3/2021/0332

Erection of a ball stop safety fence on the 1st fairway adjacent to the housing on Elbow Wood Drive, Barrow.

Barrow Parish Council Response

PROPOSED BALL STOP SAFETY FENCE ELEVATIONS

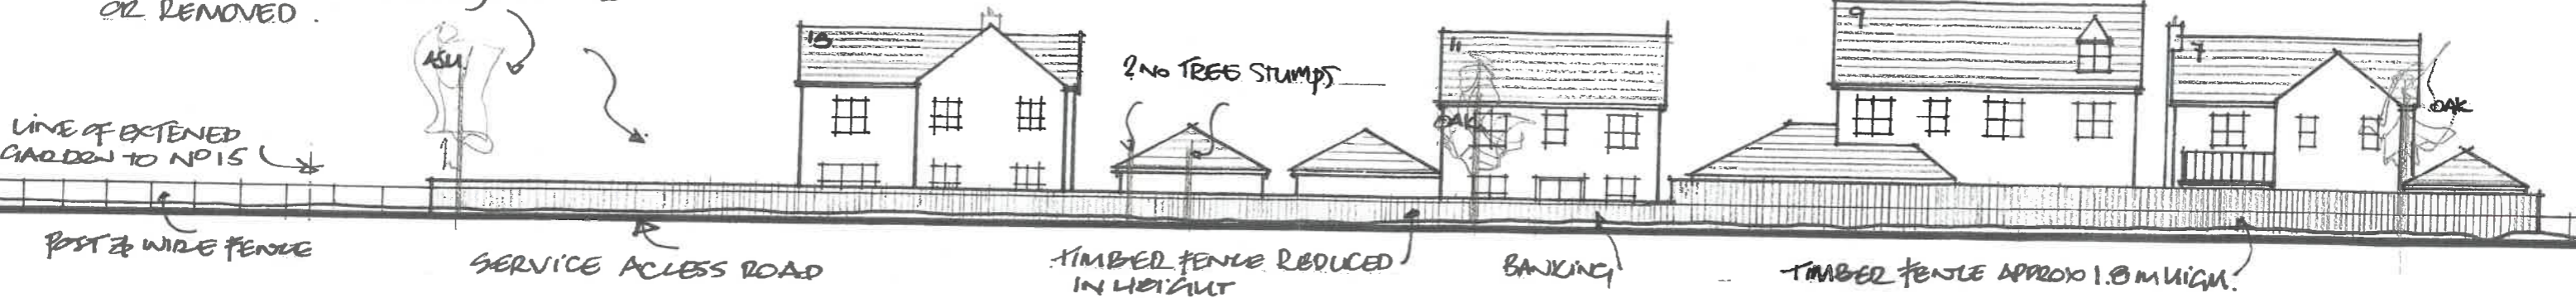
Whilst Barrow Parish Council notes the style & colour of the proposed fencing, it is difficult to comment on how this will aesthetically. It is also noted that CGC have had contact/discussion with adjacent homeowners.
